Application No: EP/22/21/HH
Site Address: 15 The Plantation East Preston BN16 1LD
Description of works: Erection of rear extension and loft conversion with rear dormers and side gables

Thank you for your internet representation made on 21st April 2021 which has been recorded as an objection with the comments as follows:

Plans & Elevations As Proposed

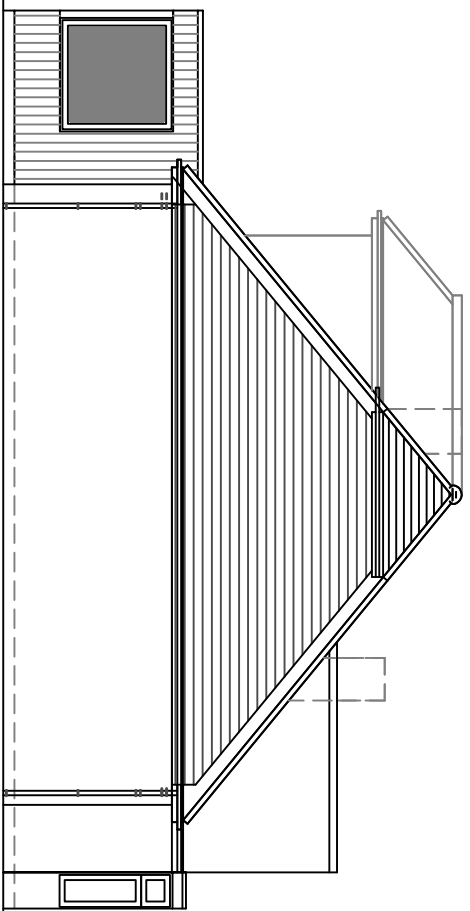
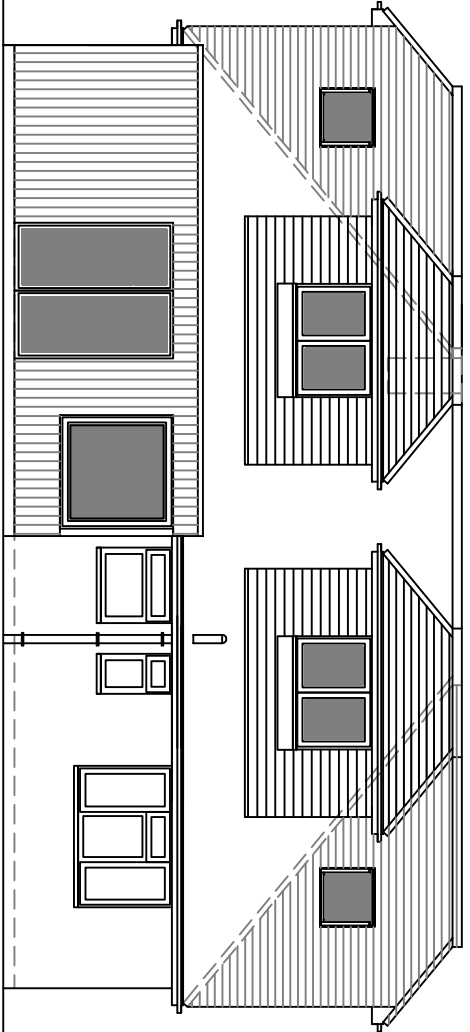
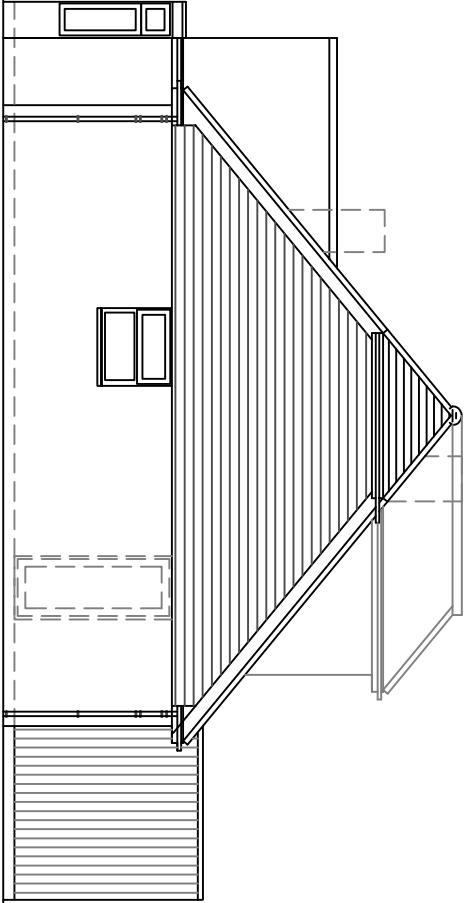
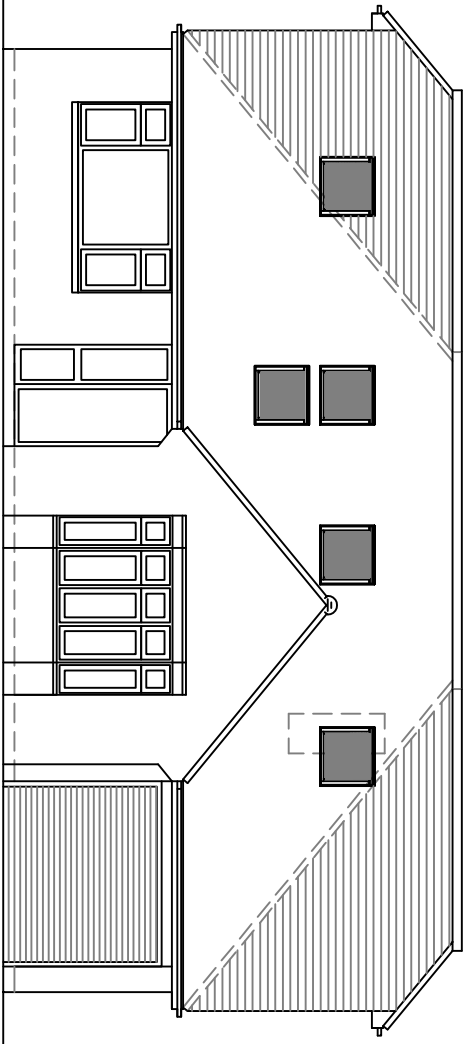
This planning application is contrary to many of the 'Development Principles', but in particular in relation to the dormer windows not being 'subservient to the appearance of the roof as a whole'.

The conversion from a 2 bedroom bungalow to effectively a house with 5 bedrooms is not 'designed to look as if they were part of the original design of the house. Is 'so large as to be out of scale with other houses in the road'.

The 'basic form of the roof' is being altered significantly, when in fact no change in the basic form is, or should be acceptable.

BLOCK PLAN 1:500

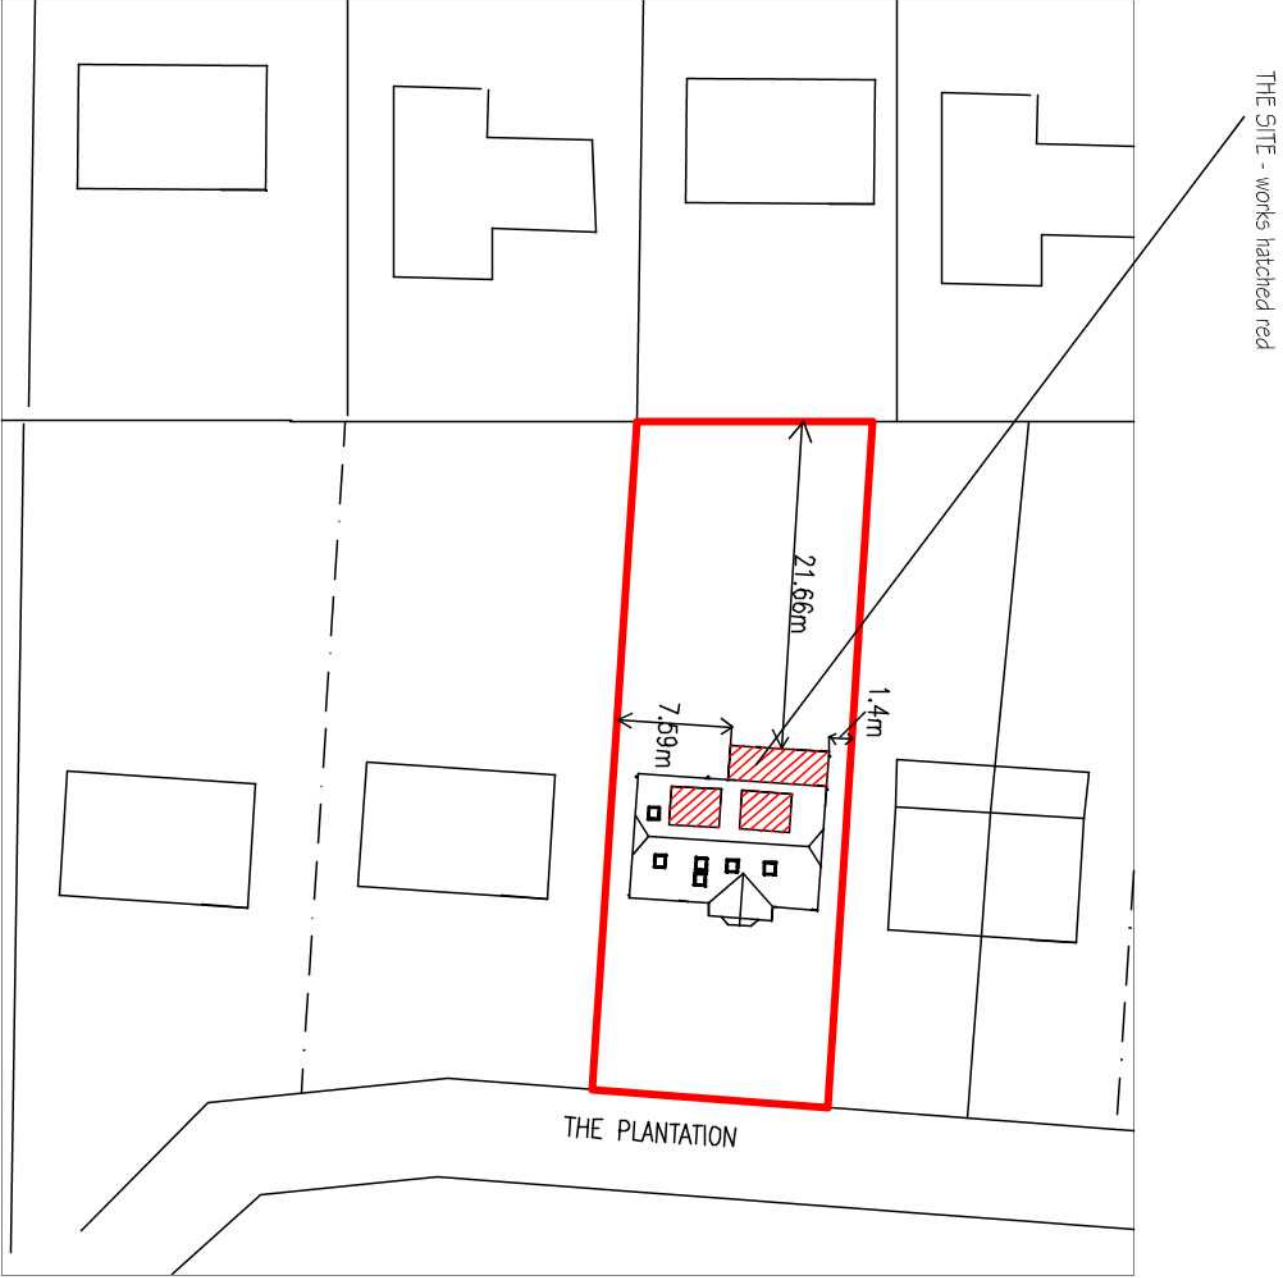
Additionally - Parking restrictions set out in the Deeds & Covenants of this and all other properties in The Plantation specifically exclude on-road parking. There is no provision detailed in this application for off-road parking to cater for the additional vehicles expected at (and to) a 5 bedroom property.
